Brackley Investments Ltd
6 Lower Farm Barns
Bucknell
OX29 6ZD

Our Ref: CM/22/21/NMA

Non-material amendment following the grant of CM/16/18/PL (APP/C3810/W/19/3227374) for:

Bairds Farm Shop, Field Rear Of Crookthorn Lane Climping BN17 5SN

05 Site Key Plan
1 : 1250

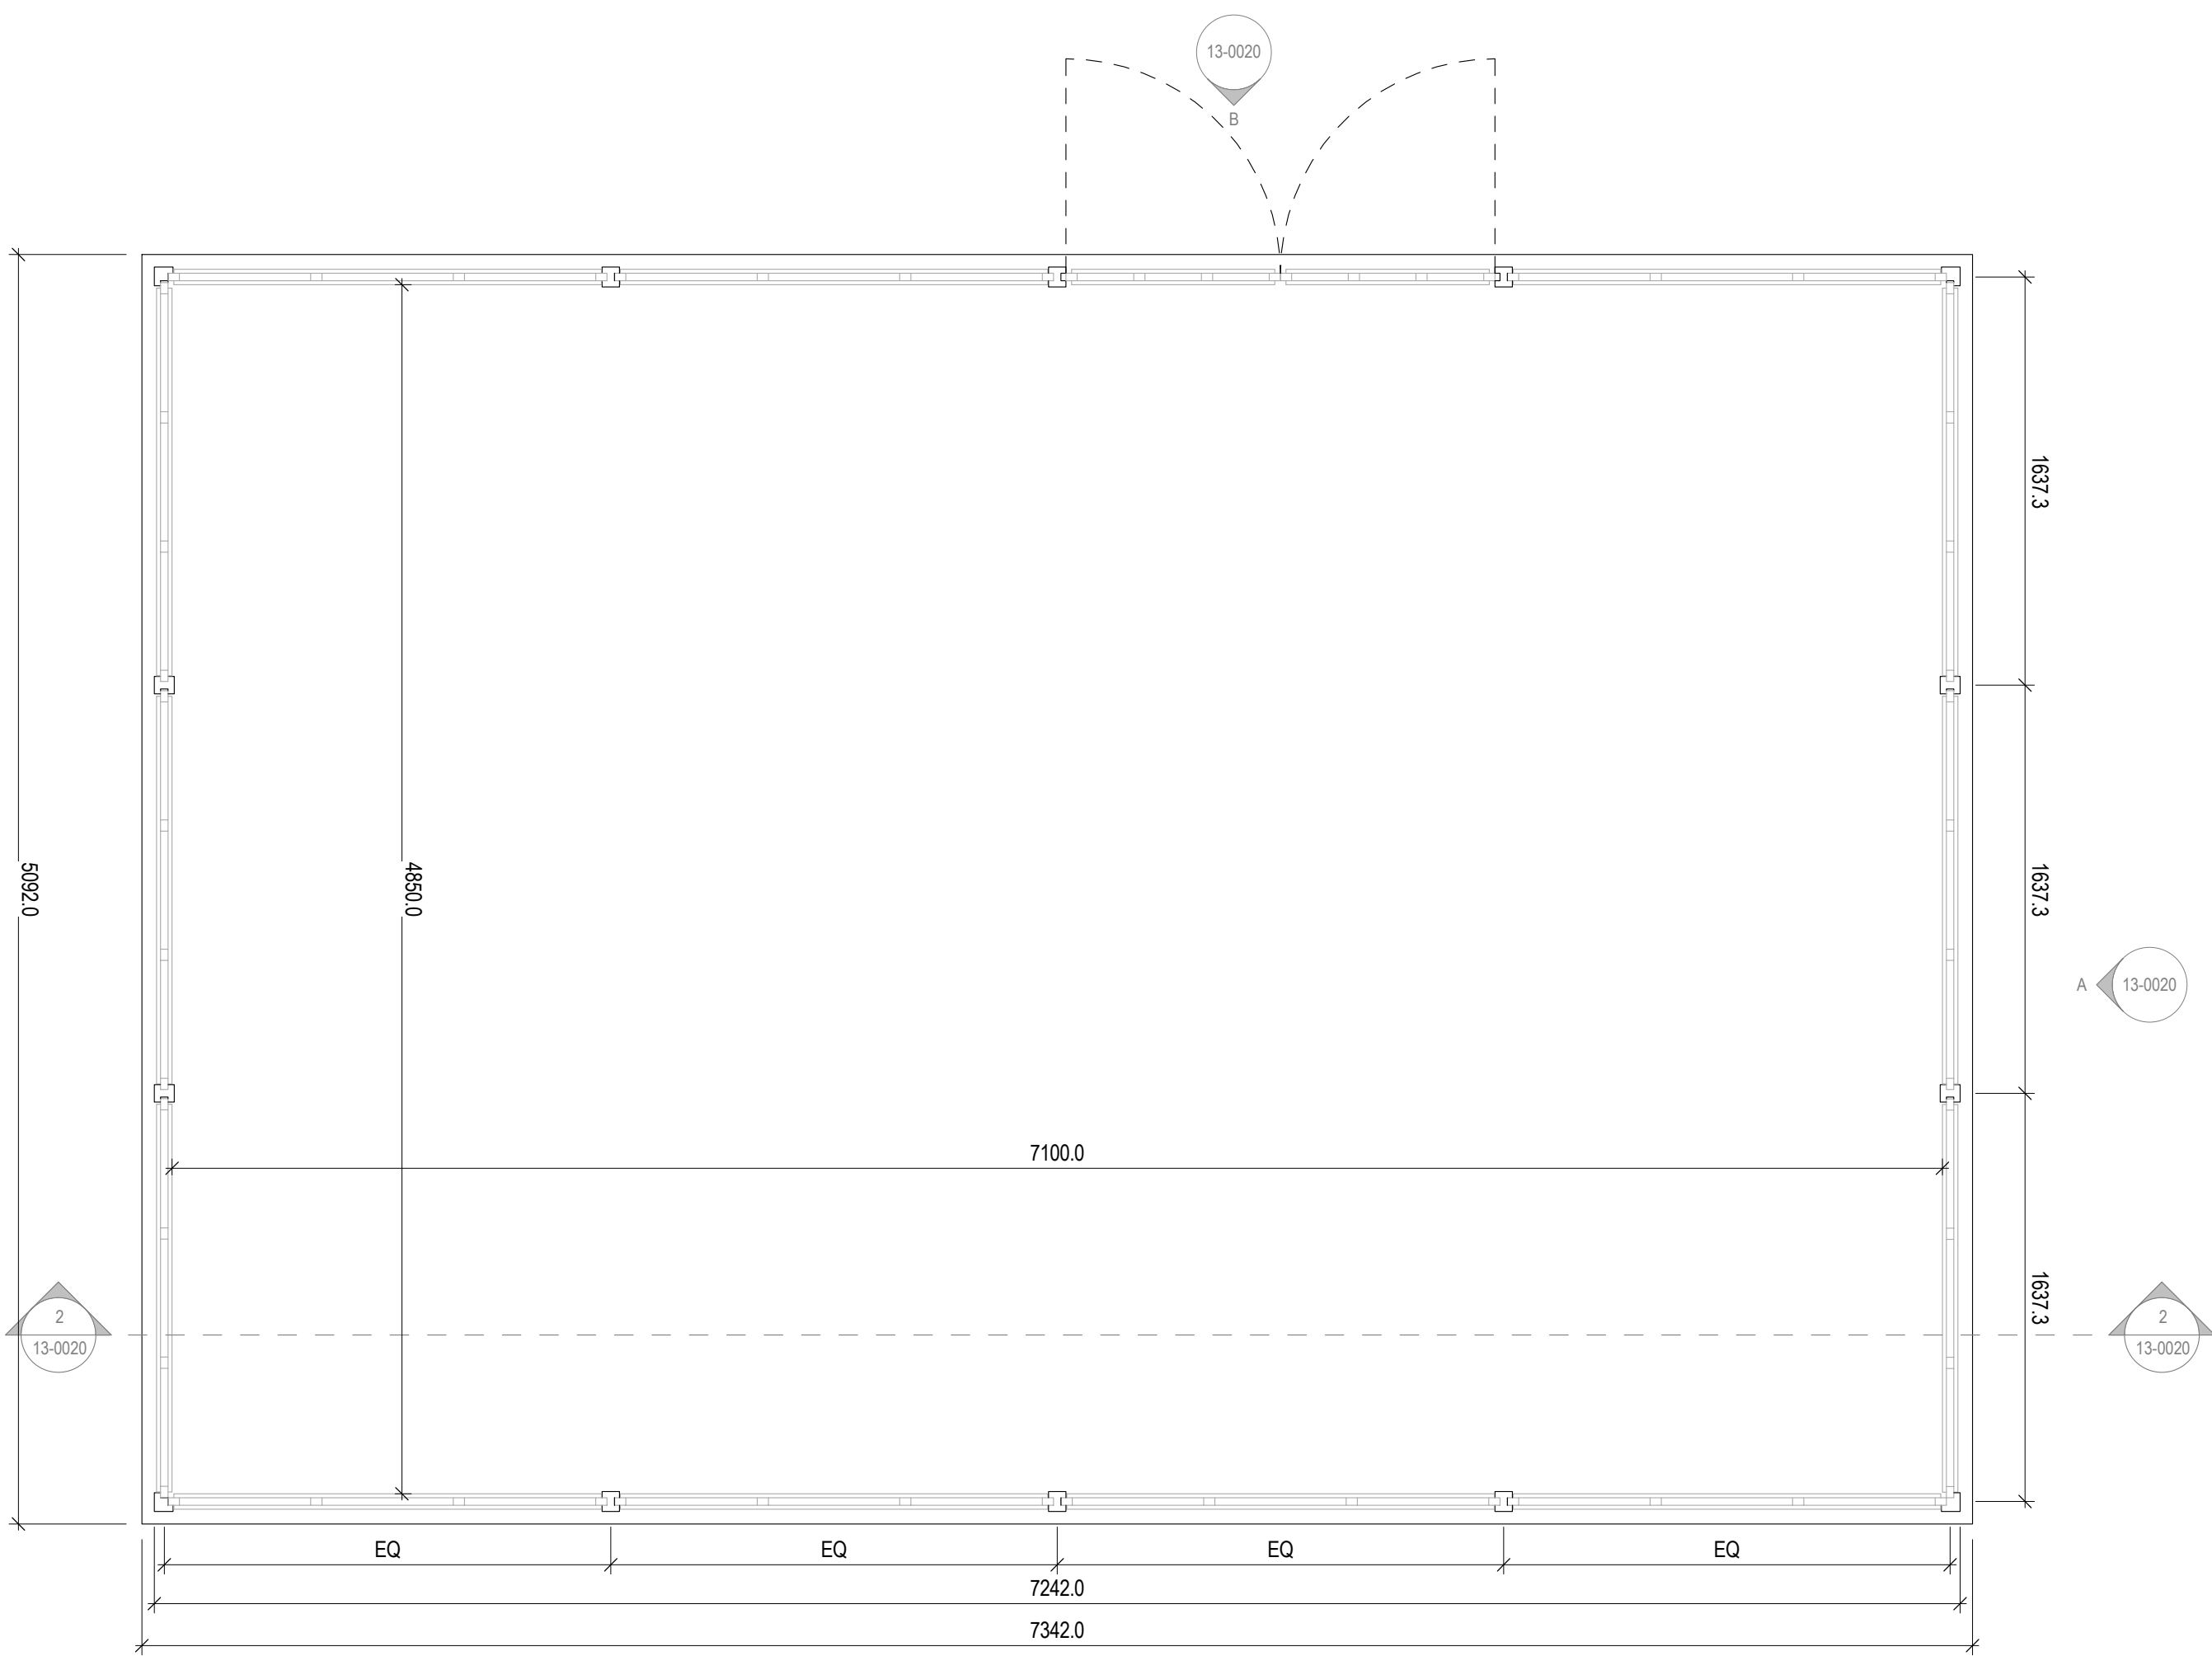
The reasons that these proposals have not been accepted as Non-Material Amendments is because the Installation of air source heat pumps within an associated enclosure together with a new electricity substation building would warrant re-consultation with Council departments and statutory bodies and

the structure is of significant size and cannot therefore be considered under section 96A of the Town and Country Planning Act 1990.
